**Consultation Response from KC,
Highways Development Management****2023/91626 adj, 275, Longwood Road, Longwood, Huddersfield, HD3 4EL****Demolition of outbuilding and erection of detached dwelling****Date Responded: 7-8-2023.****Responding Officer: Mark Berry****Responding Ref: 2-18SE-9.**

This application seeks approval to the demolition of an outbuilding and erection of a detached dwelling at land adjacent to 275, Longwood Road, Longwood, Huddersfield.

Description  
**Site Plan & Site Section**

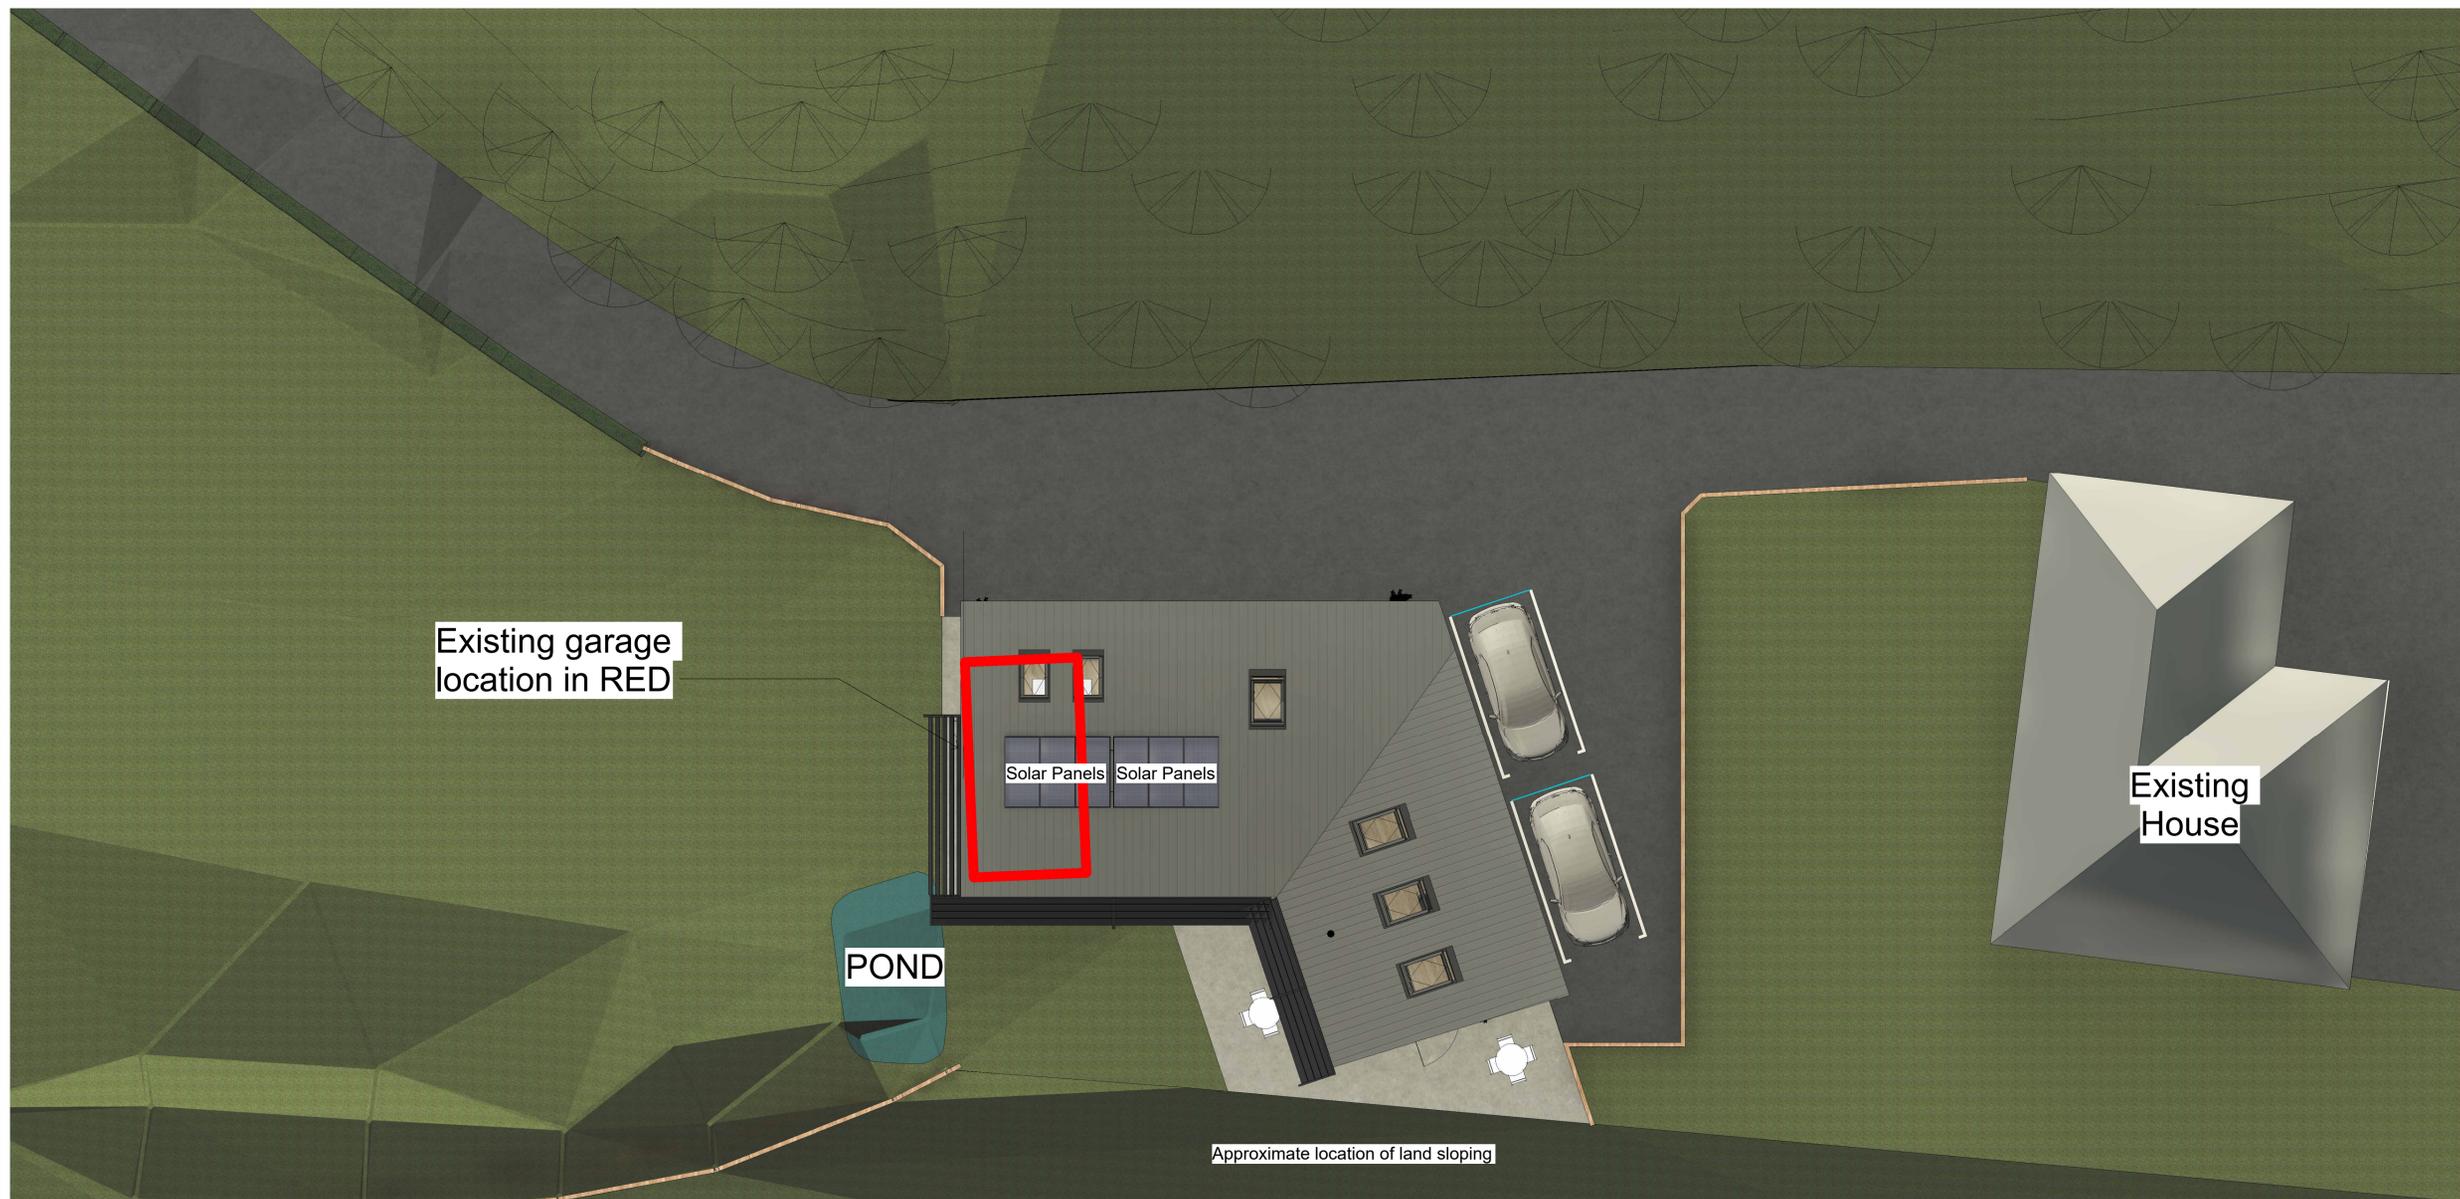
2 A site plan showing the location of the proposed 2-bedroom detached bungalow together with details of two off-street parking spaces and internal vehicle turning.

This application therefore provides insufficient information. Further details are needed as follows:

A, Details of the width and gradients of the existing driveway.

The width of the existing driveway should be a minimum of 4.5m at the access from Longwood Road to potentially allow vehicles to pass and not wait on the highway.

B, Details of sight lines from the existing access onto Longwood Road.

C, Details of proposals for emergency vehicle access.

In this case the proposed dwelling is over 45m from Longwood Road and the driveway is over 20m in length

D, Details of proposals for the storage and collection of waste from the site.
